Case Officer: Chris Wentworth **Recommendation:** Part Approval

Applicant: Heyford Park Developments Ltd

Proposal: Discharge of Condition 38 (Flying Field strategies) of 18/00825/HYBRID

HEYFORD PARK - PROPOSED CAT AND DOG PROOF FENCE (CONDITION 14)

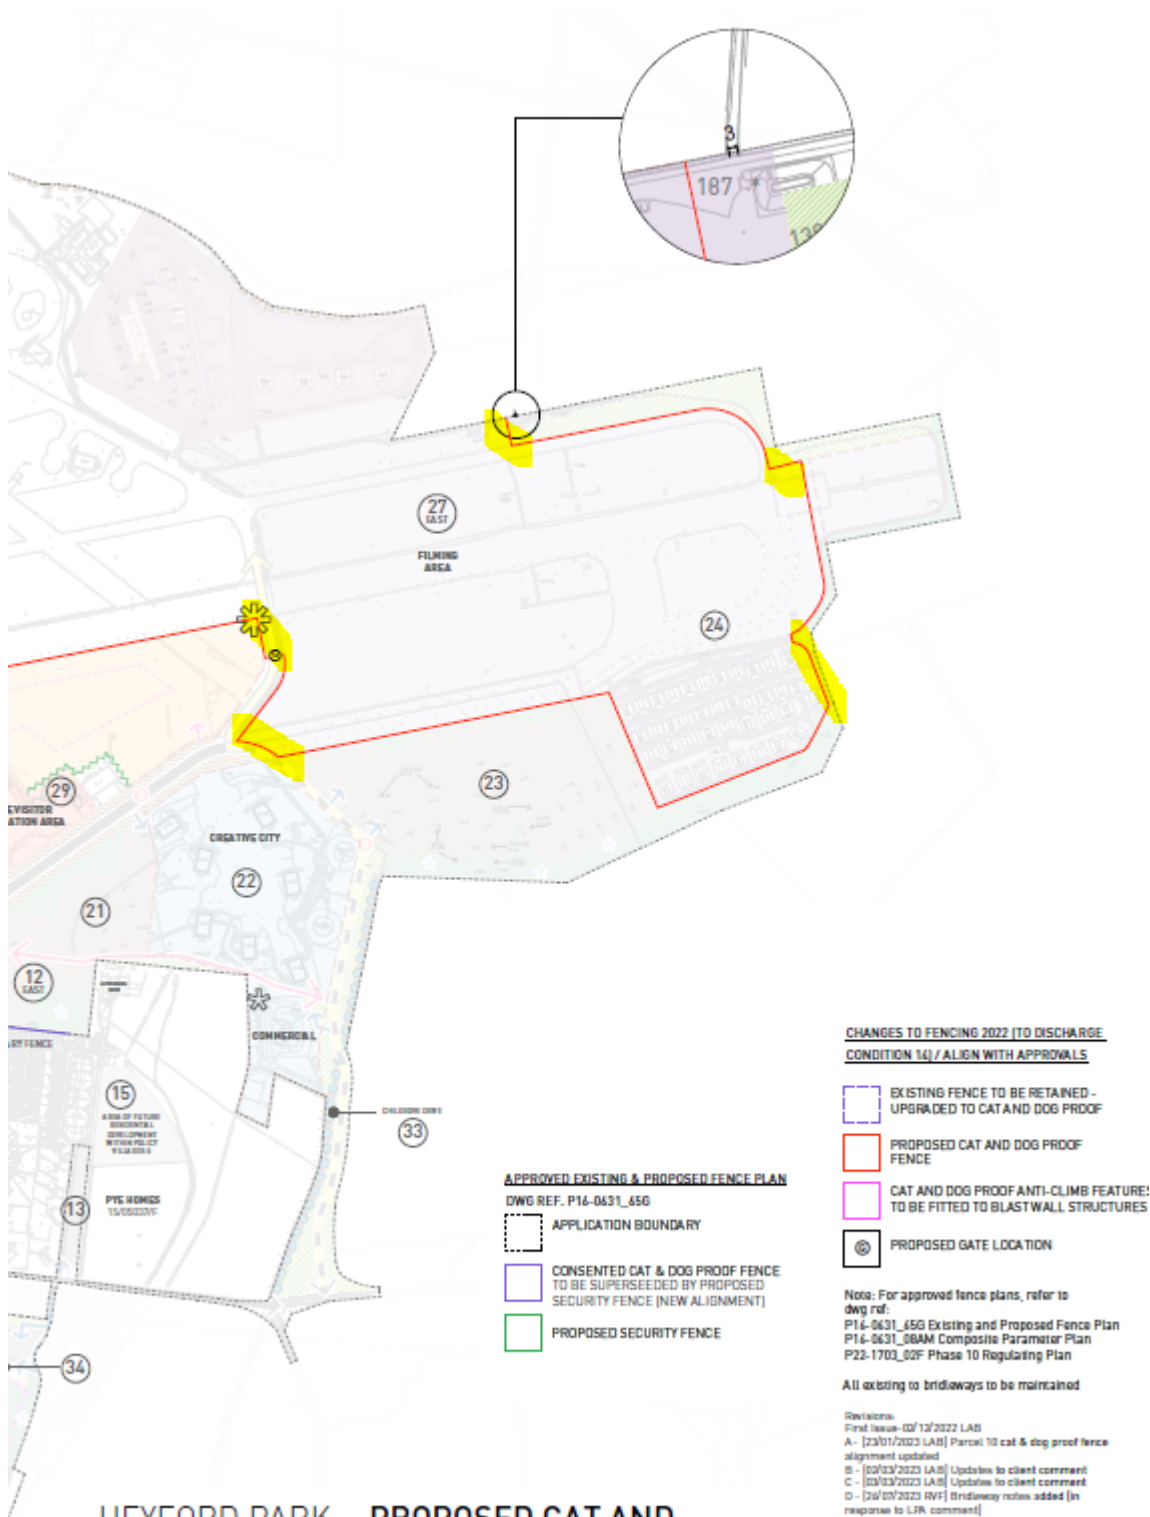
- The Fencing Strategy has implications for public rights of way requirements. It does not provide for the perimeter fence to be changed to reflect:
 - The requirement to reopen Aves Ditch. This was condition 30 on the 2011 planning permission (and in the S106 agreement) and required details of the Aves Ditch route to be submitted within three months of that planning permission and implementation within 18 months of that. Despite repeated reminders, details have still not been submitted, 12 years later. Aves Ditch is a critical local bridleway link that must be reopened in the interests of sustainable transport connectivity and affording leisure opportunities to local people that are currently denied to them. OCC expect that CDC will not discharge condition 38 of 18/00825/HYBRID until this is resolved.

- The requirement relating to the Heritage Trail on the northern perimeter of the flying field, where the legal line of footpath 349/13 (which forms part of the trail) runs inside the boundary. The perimeter fence must be moved to accommodate the legal line of the footpath or Dorchester must negotiate a diversion by working with neighbours. If progress is being made towards the latter, this must be referred to in the strategy and the strategy must be conditional upon this, with regard to a requirement to move the perimeter fence. OCC require an update on this matter. Whilst unresolved, this is again denying legitimate leisure opportunities to local people.

- The opening up of the extension of Chilgrove Drive, which is to form the main bus and HGV route into the development. This will necessitate widening the opening in the fence.

- It also does not acknowledge Portway bridleway, which has already been opened and fenced off across the western edge of the flying field.

5.2 It is noted that the Fencing Strategy submitted as part of the original application, which attracted objections from the County Council as Highway and Rights of Way Authority, was subsequently withdrawn from the submission. A revised Fencing Strategy will need to be submitted to and approved by the LPA before Condition 38 can be fully discharged.
